March 11, 2025

Re: Panda Express at 2040 Gibson Blvd SE (Lots C-1 & C-2 Lovelace Heights Addition.)
Erosion and Sediment Control Plan (Sheet C06.1)
Engineer's Stamp date 3/5/25 (M15E021F) SWQ-2025-00012

Principal Engineer, Planning Dept.
Development and Review Services

2.7 ESTABLISH PERIMETER CONTROLS AND SEDIMENT BARRIERS

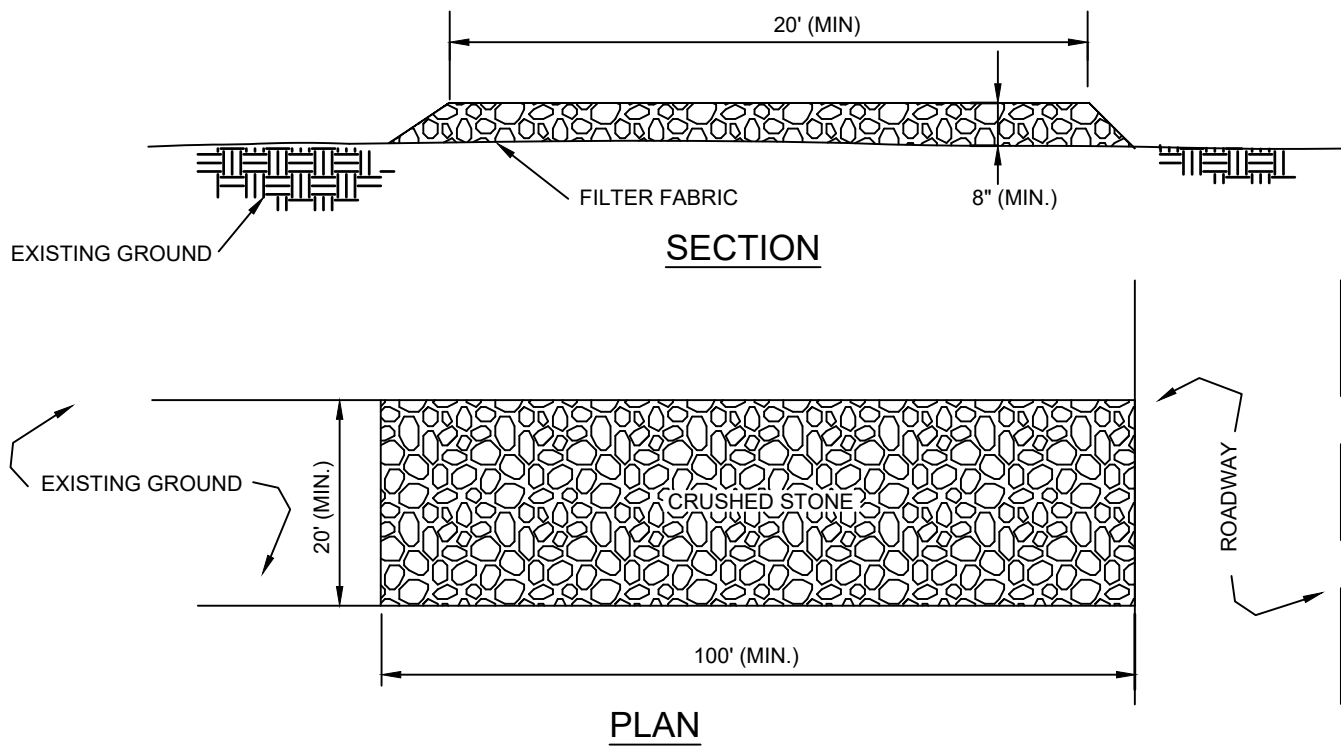
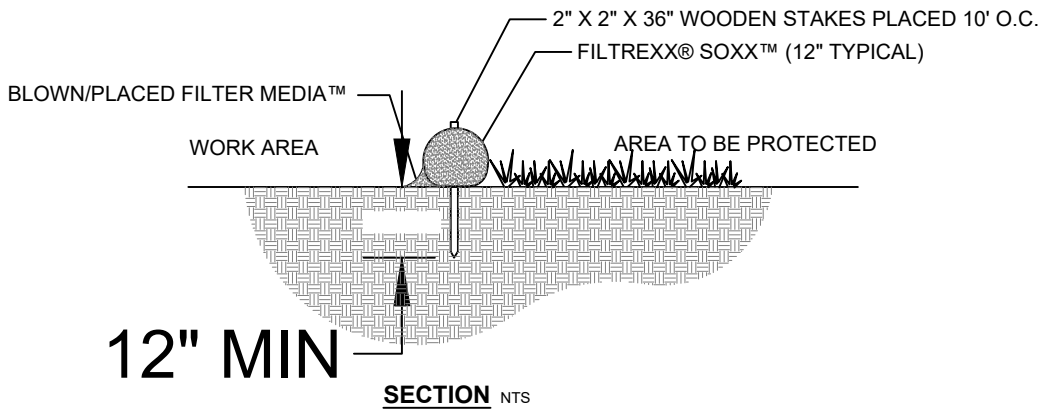
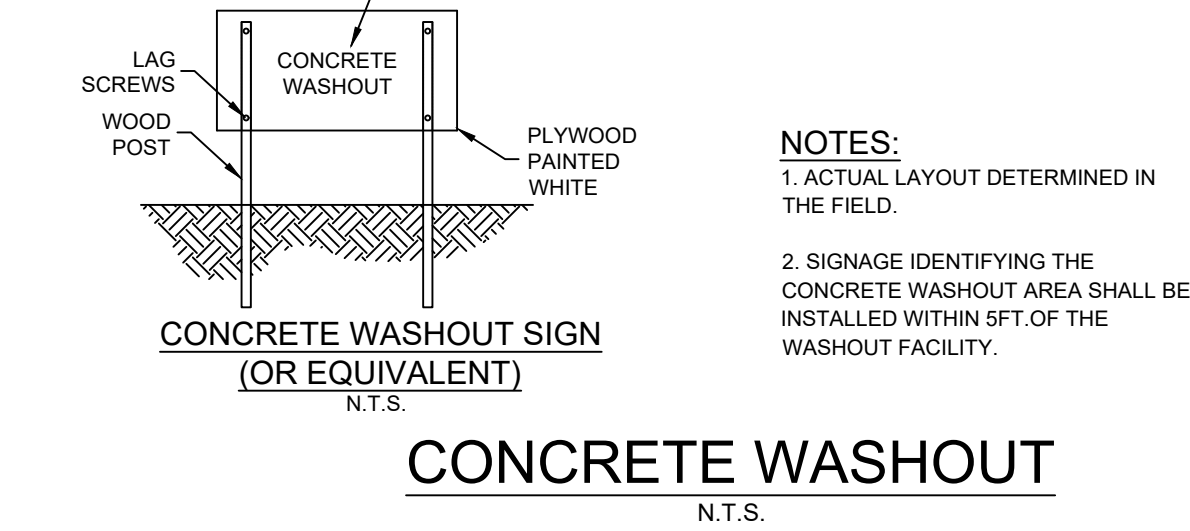
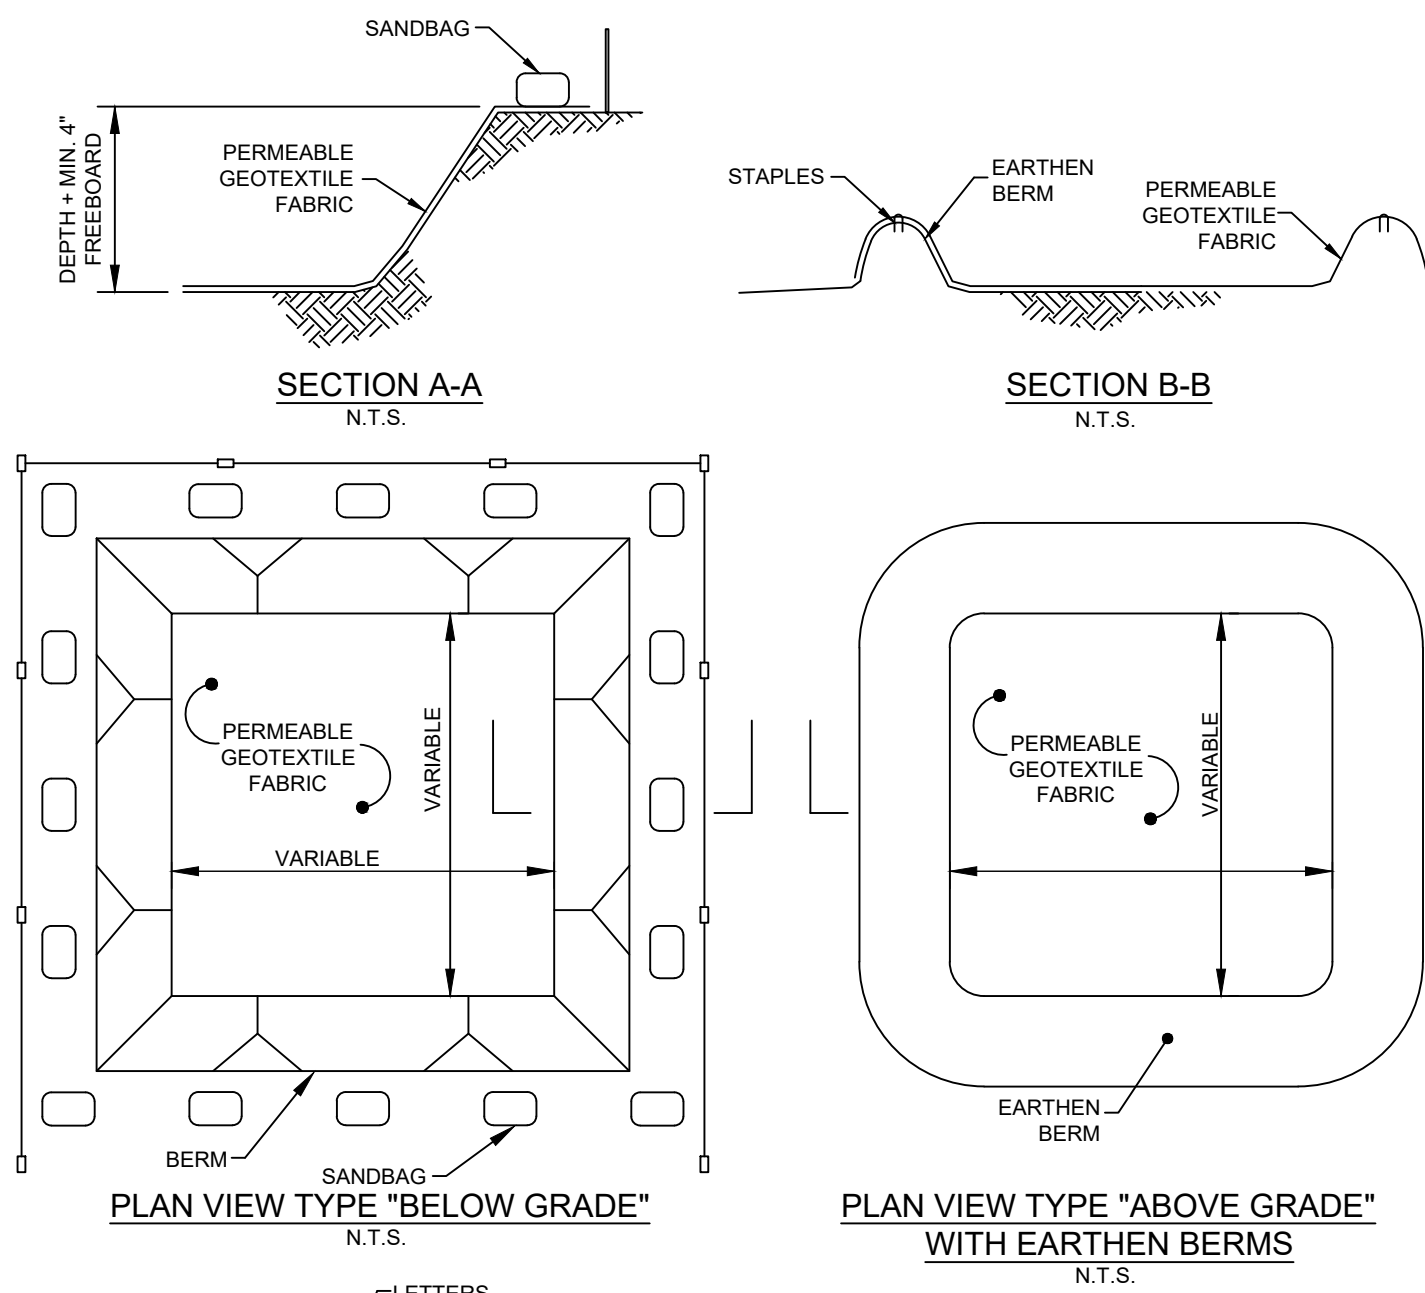
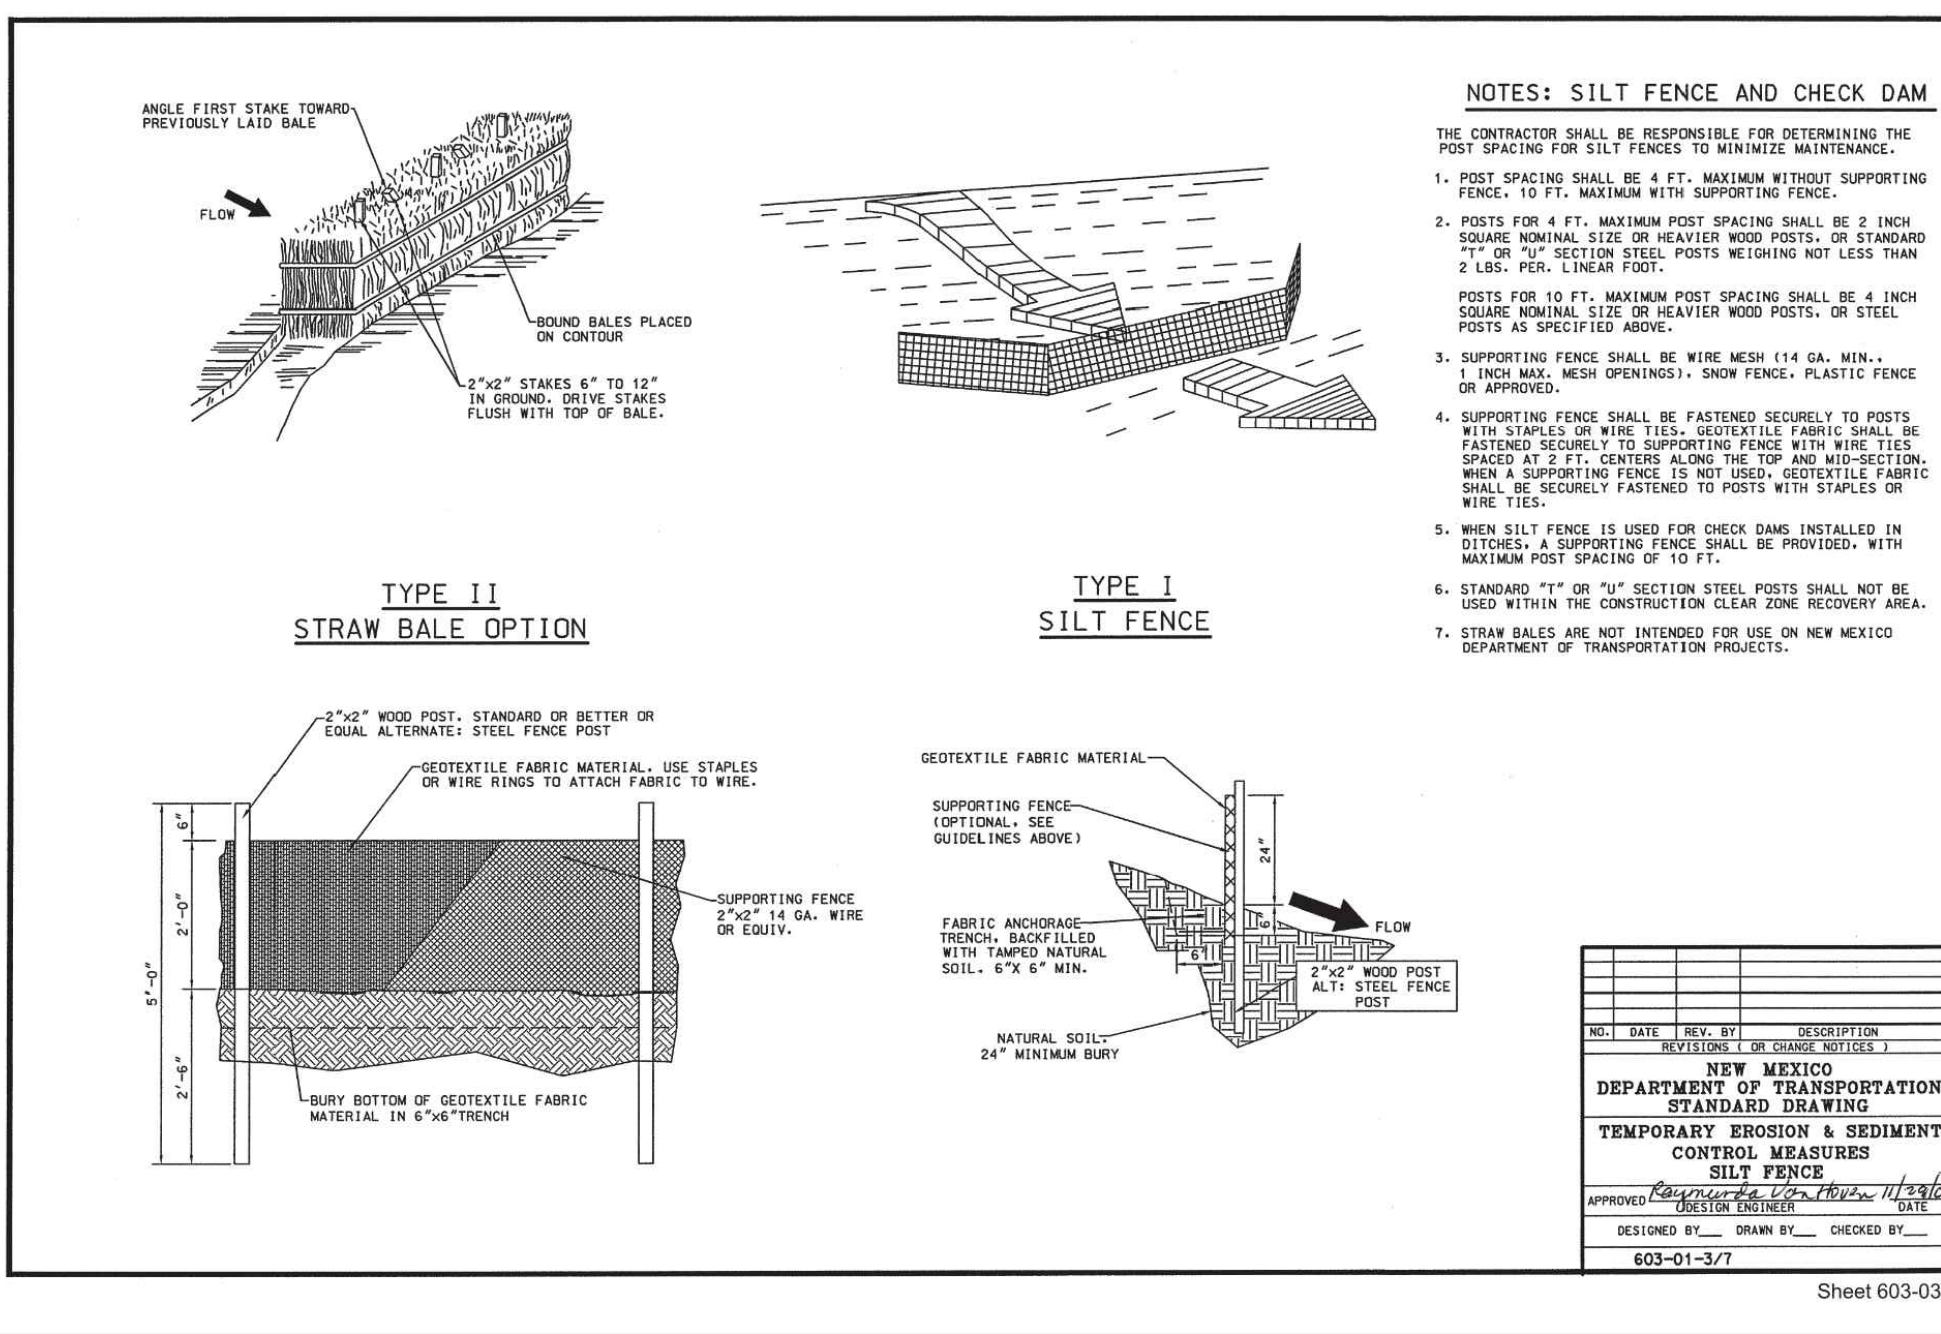
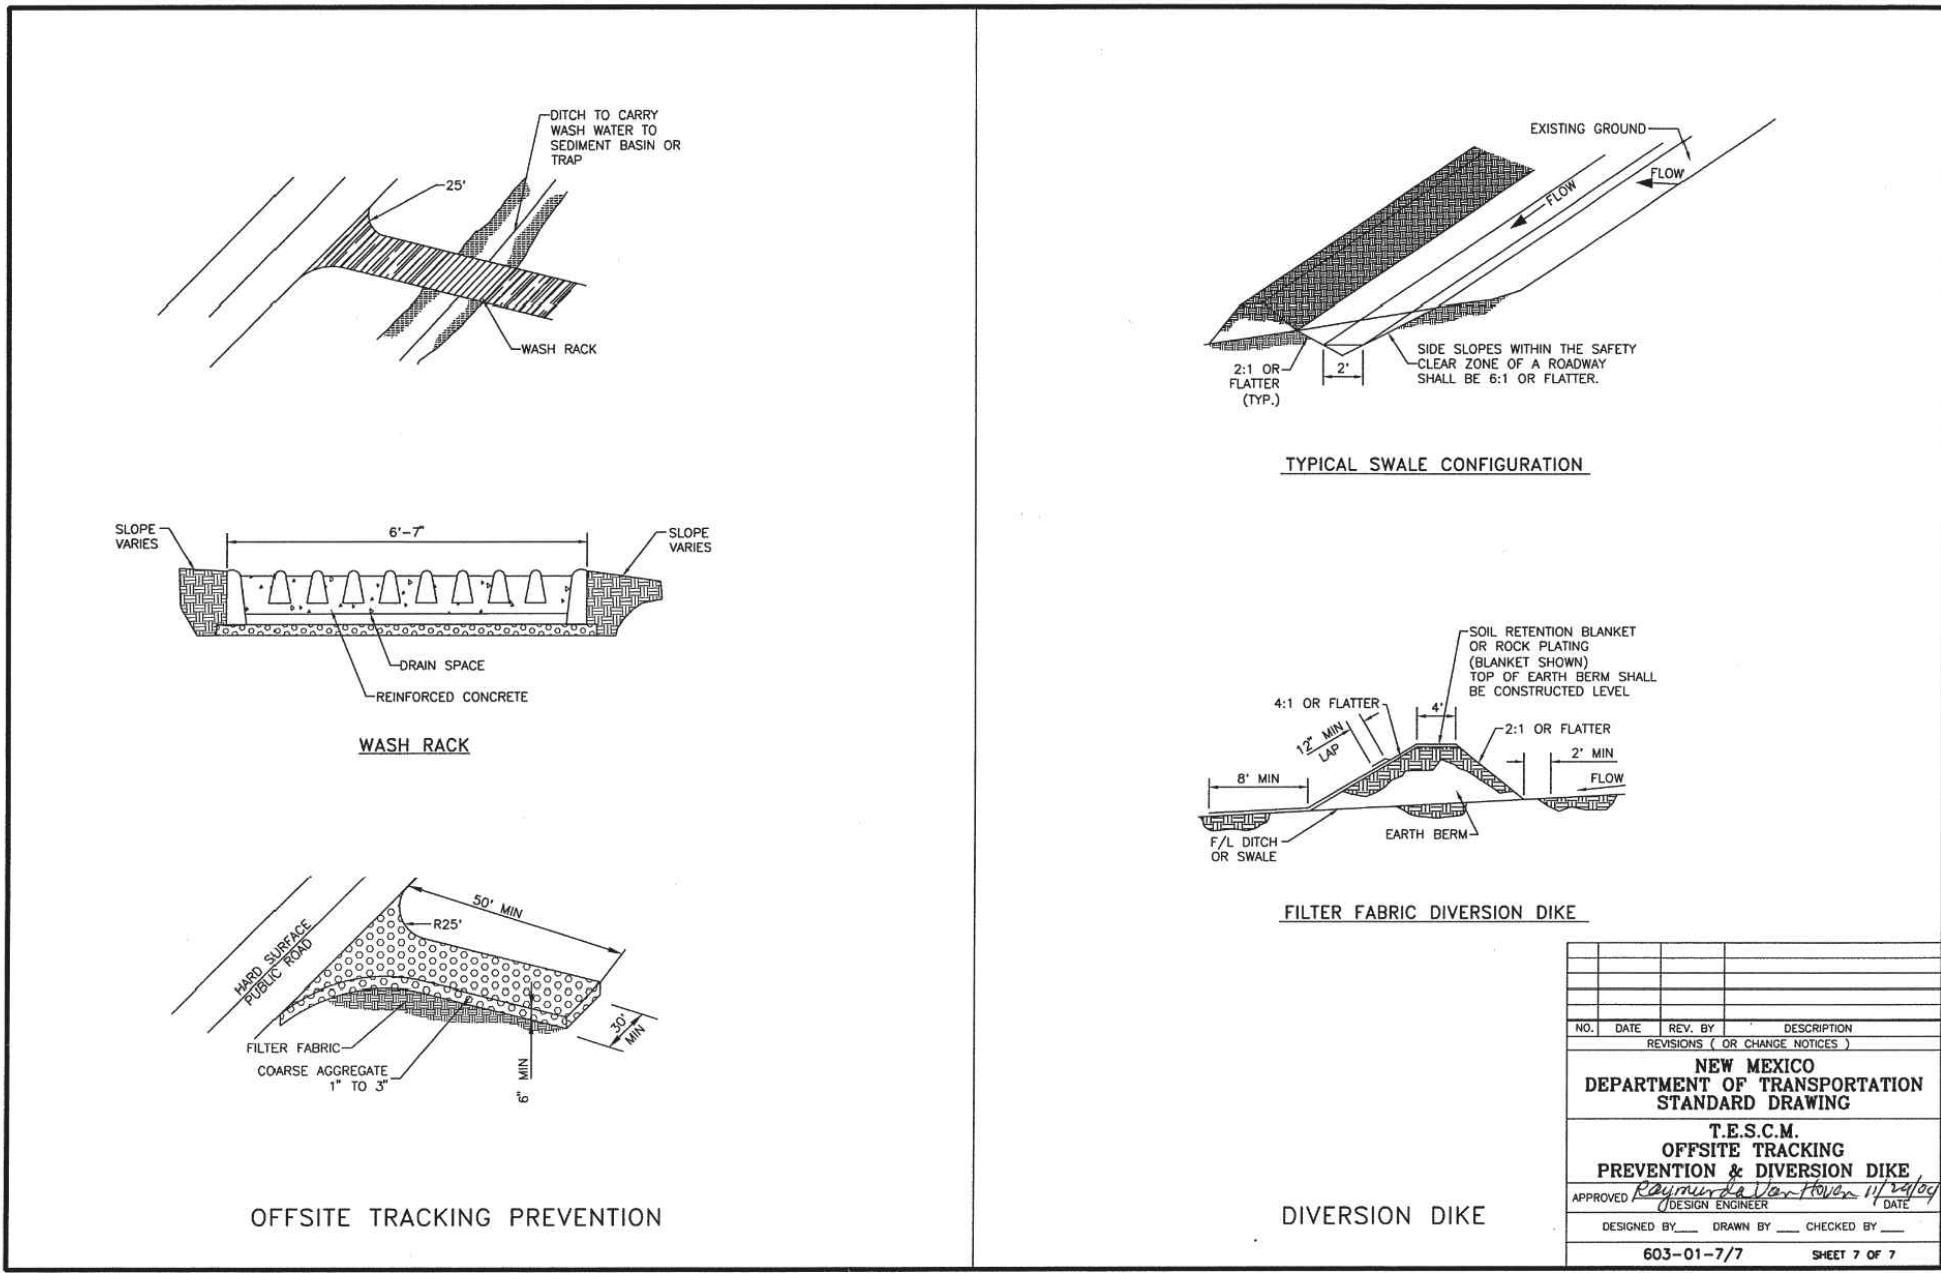
9. The SWPPP must include site-specific interim and permanent stabilization per CGP 9.6.1.c.i. The Landscape Plan can satisfy this requirement. It should be stamped and signed by a registered professional landscape architect, submitted separately from the ESC Plan with the application to the Stormwater Quality Section of the Planning Department, and included in the SWPPP. Provide specifications, like those in section 7 of the SWPPP, on the ESC Plan for any disturbed areas not covered by the Landscape Plan. **The Landscape Plan provided with the resubmittal is acceptable for Lot C-2, but stabilization specifications are missing from the ESC Plan for the disturbed portions of the adjacent lots. Provide construction specifications on the ESC Plan for rock that will satisfy Part 2.2.14.C.ii of the CGP.**

10. Update the engineer's stamp & date on all sheets each time the plan changes. **Sheet C06.1 was the only sheet in the resubmittal. The ESC Plan, Sheet C06.0, was missing from the resubmittal. Update the engineer's stamp & date on all sheets each time the plan changes.**
